PLANNING AMENDMENT

H16/0583/02/A1

Description: Proposed new warehouse and offices and proposed glasshouse to replace polytunnel

Amendment: Alterations to fenestration & front door & change fire escape stairs to spiral. (Dwg. Nos 047/1/2003 & /2/2003)

DETAILS
Elevations / Section

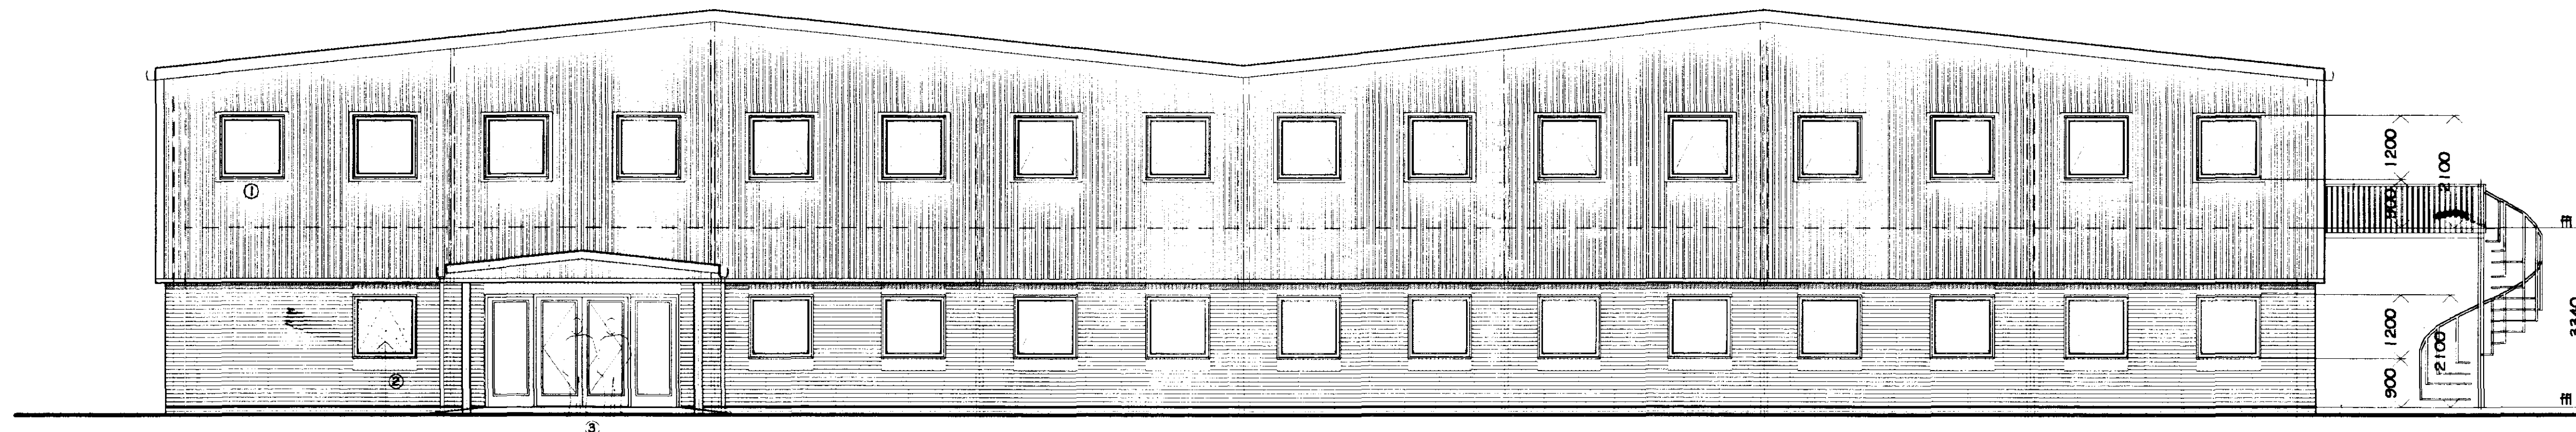
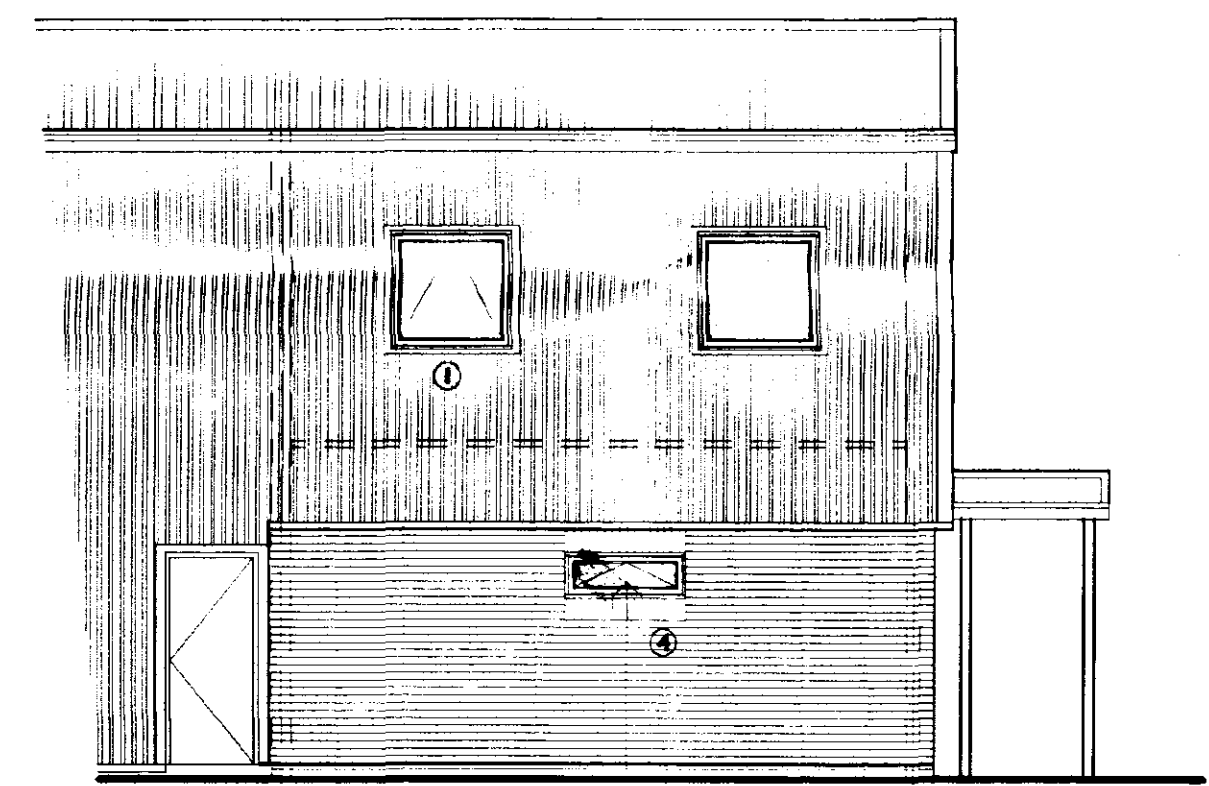
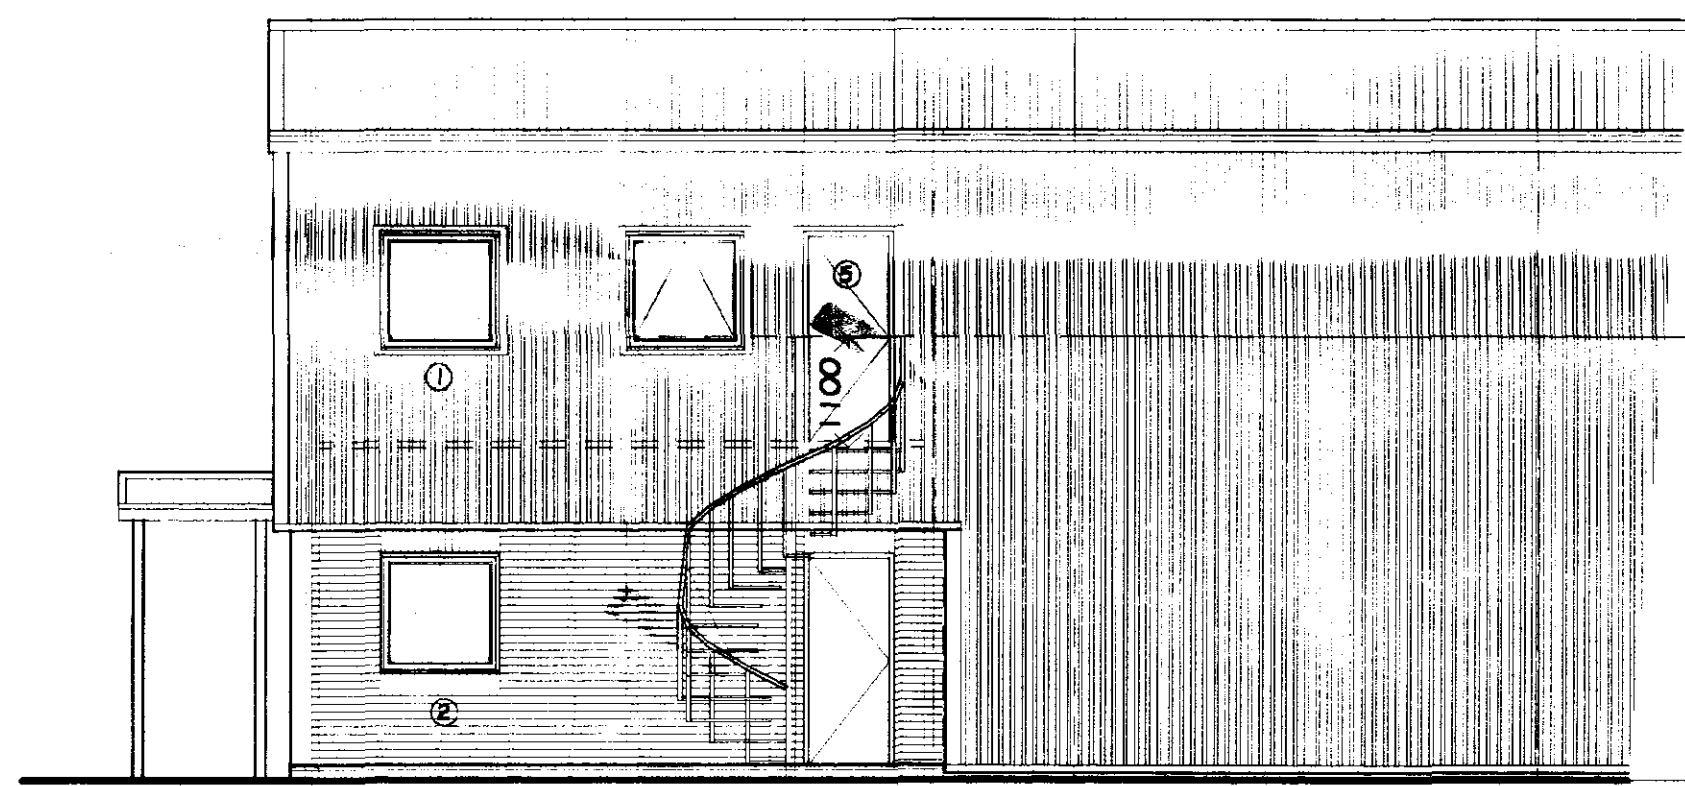
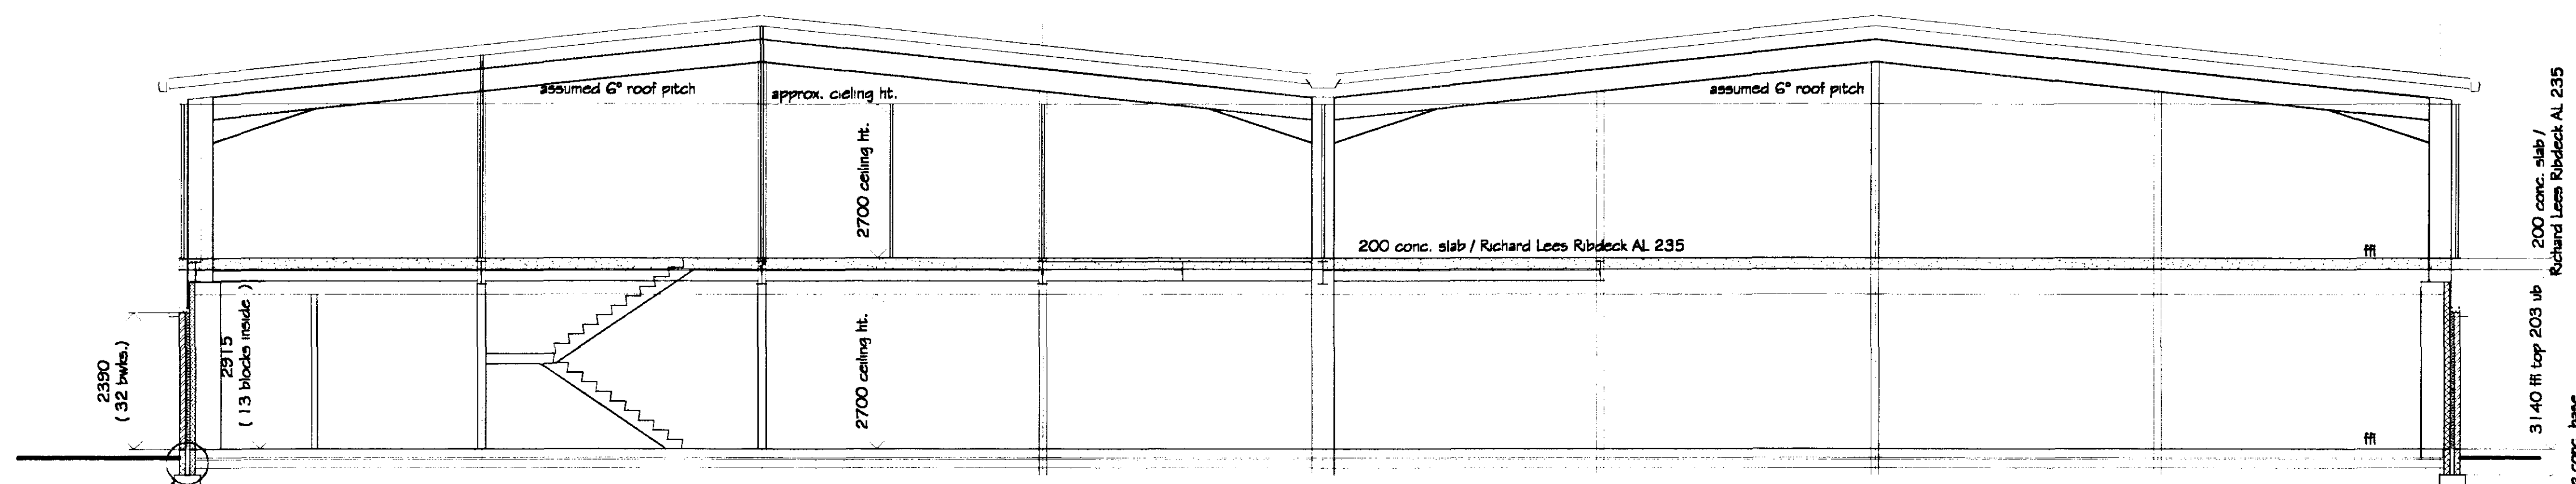
REMOVED NEW WINDOW & DOORS
SAME EXISTING
REVISION TO OFFICE ONLY
INTERNAL OFFICE AND
REMOVED.
NEW WINDOWS ADDED / REMOVED
SEVERAL STAIRCASE TO REAR
STRAIGHT FLIGHT / FIRST
FLOOR ONLY. 24/1/2003
04/1/2003
MR. P. O'D.

The amended details submitted in respect of the above proposal have now been considered and there are no objections to the amendment being implemented to the extent described above.
